Planning Officer: Mr S Davis

Planning Application Ref: AL/51/19/PL

Location: Springfield and land to rear, Hook Lane, Aldingbourne, PO20 3TE

Description of works: Demolition of the existing dwelling & erection of 3no. 2-bed, 3no. 3-bed & 4no. 4-bed dwellings, access, landscaping & associated works

Drawing Title		Drawing No.	
Engineering Details		KNC1932	
Drainage Strategy		602-01	
Drawn	Checked	Scales	Page Size
KN	KN	1:250	A1
Job No.	Drawing No.	Date	Revision
KNC1932	602-01	09.19	A

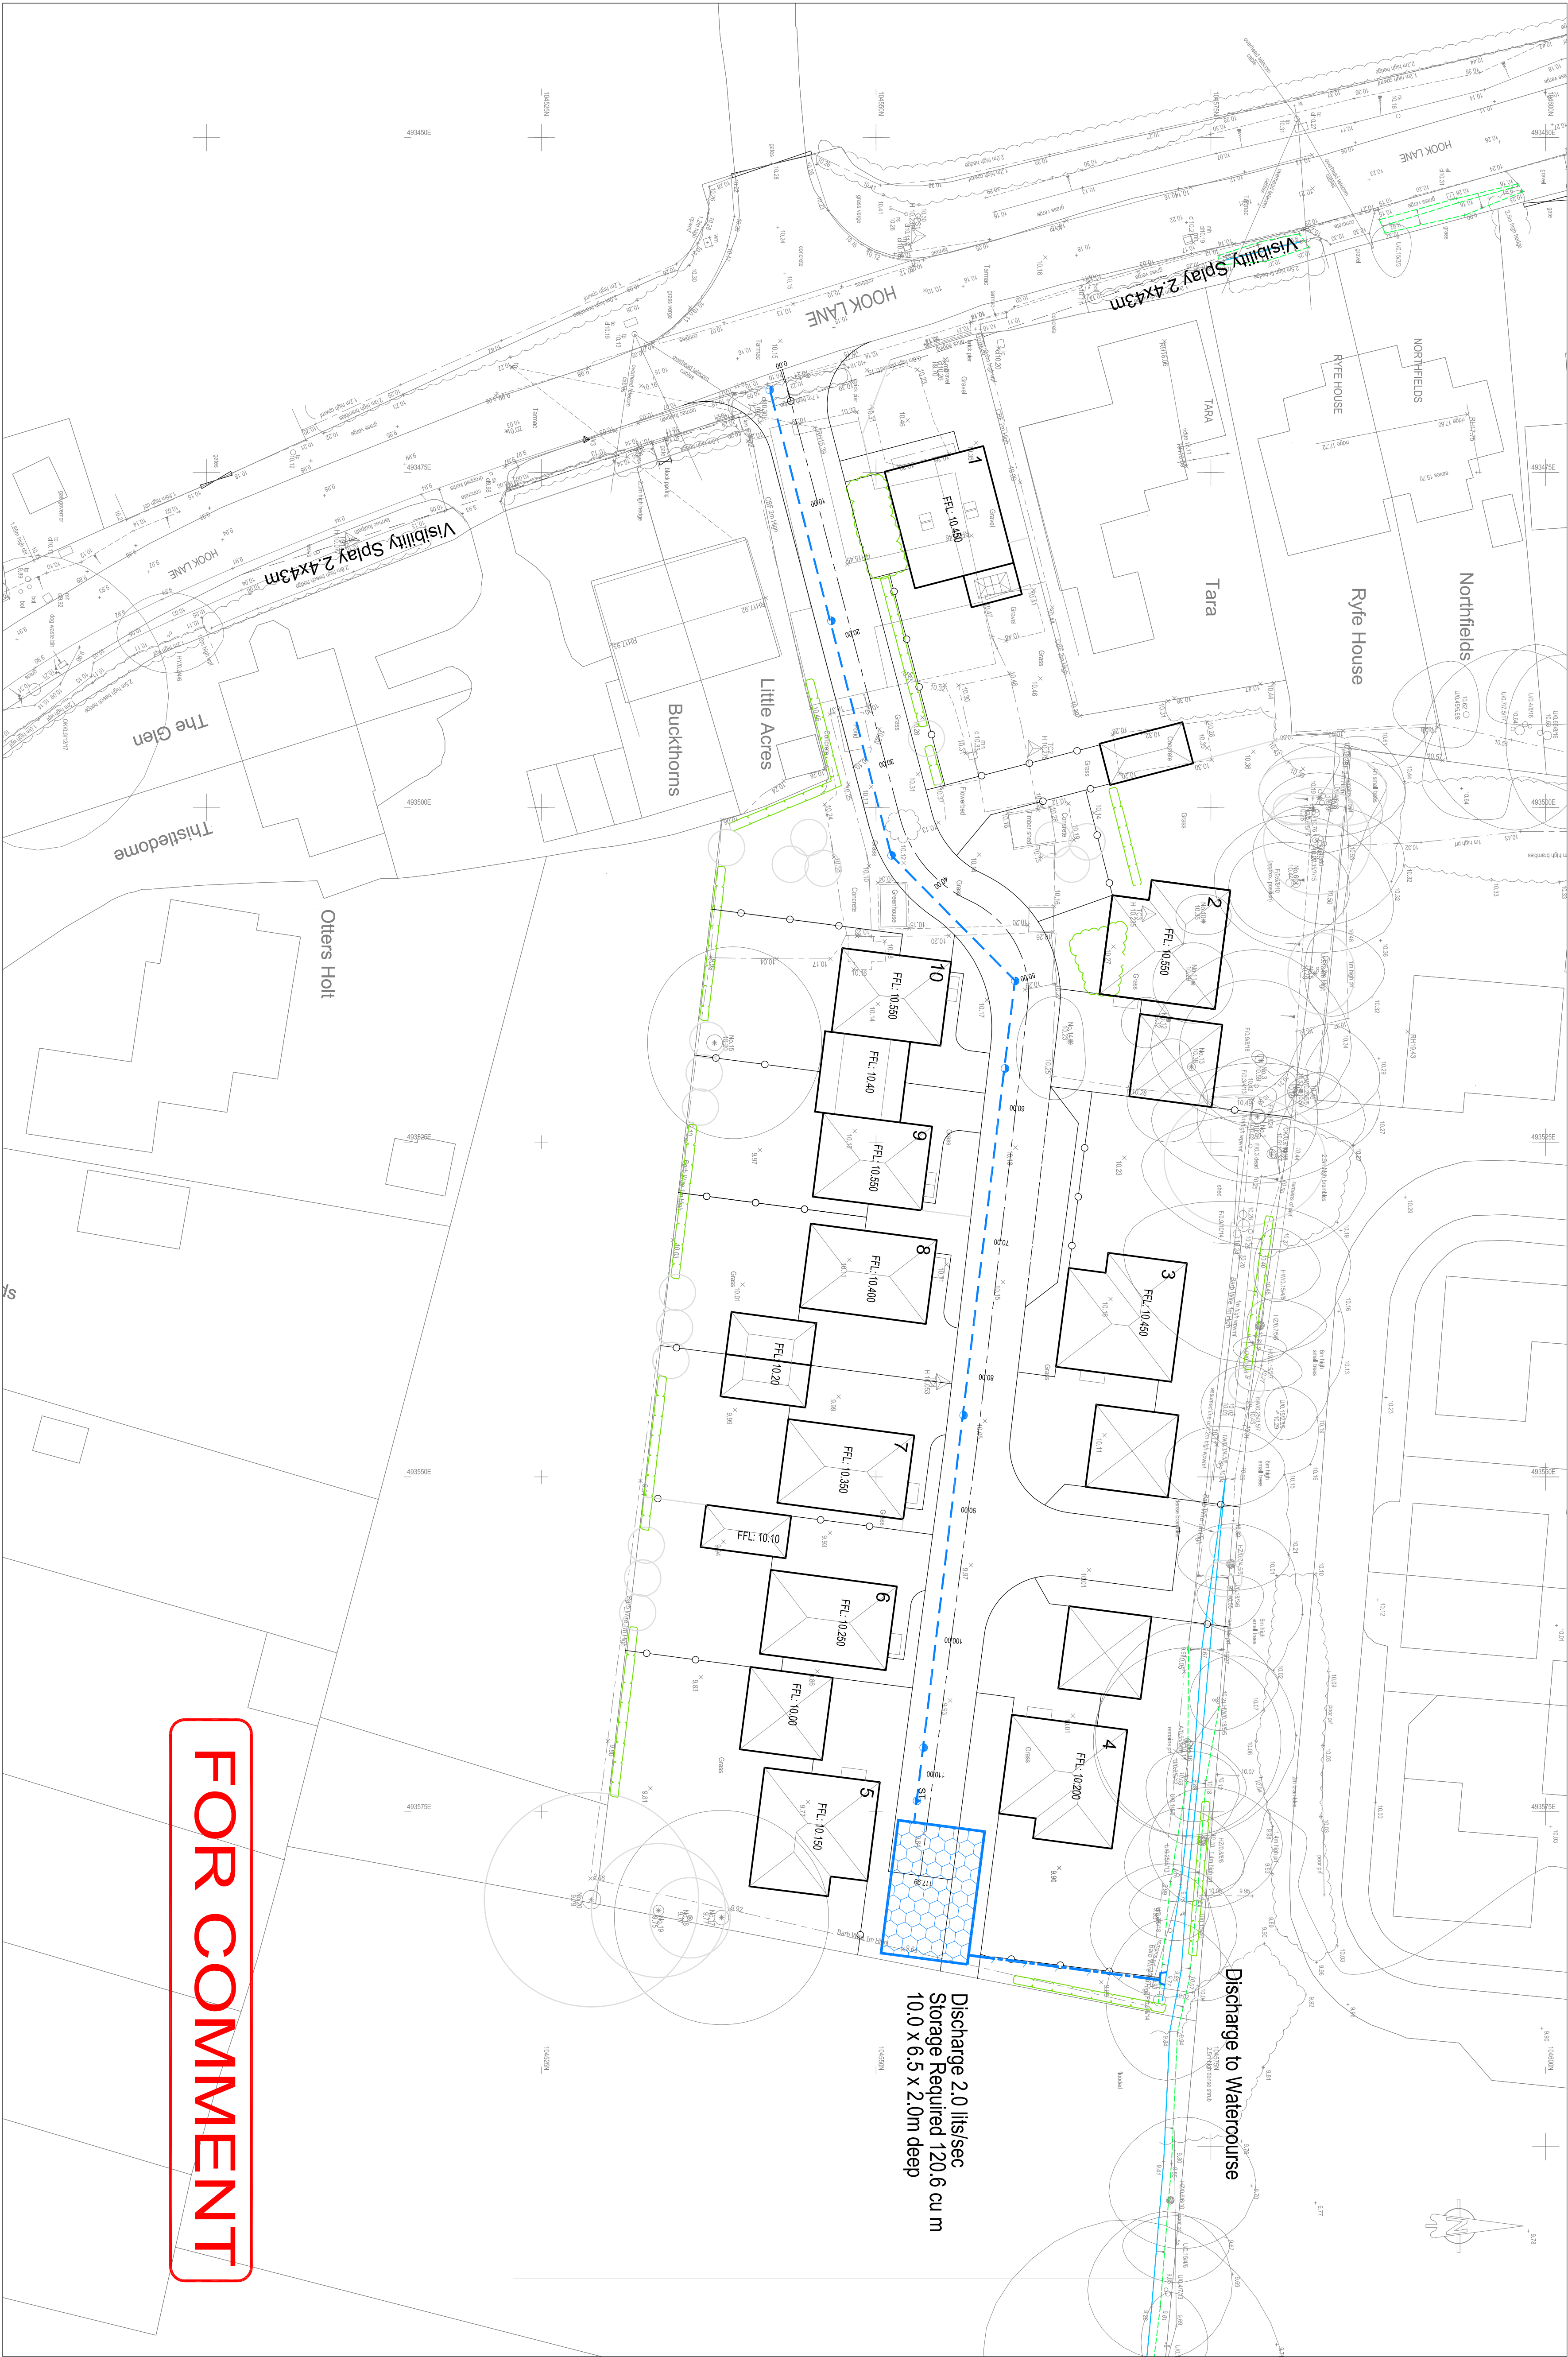
- I have subsequently been able to note the following plan: Engineering Details Drainage Strategy, dwg.no. 602-01, Rev A, 09.19. This shows what I assume to be a subterranean construction (attenuation tanks?) well within the root protection area of an off-site oak tree. That oak tree (T23) is a Category A tree and the subject of my recommendation for statutory protection (Tree Preservation Order). It has not been shown on the above plan. Outwardly and from a distance it appears to have high growth potential. The root protection area of this tree should remain sacrosanct – as shown on the Tree Protection Plans.

- Should this application proceed to development then the drainage strategy would have to be revised to avoid incursion into the RPA of off-site tree T23, the most valuable tree overlapping the development. The potential for expansion of its root system would also have to be taken into account as part of that revision. I see no revision to the drainage strategy, so my concerns in that respect remain. It is worth reminding ourselves that this fundamental element of the design ought to be addressed to our satisfaction in association with layout proposals, so that we are not subsequently held hostage to flood mitigation measures which could then impact heavily on retained trees or landscape plans.
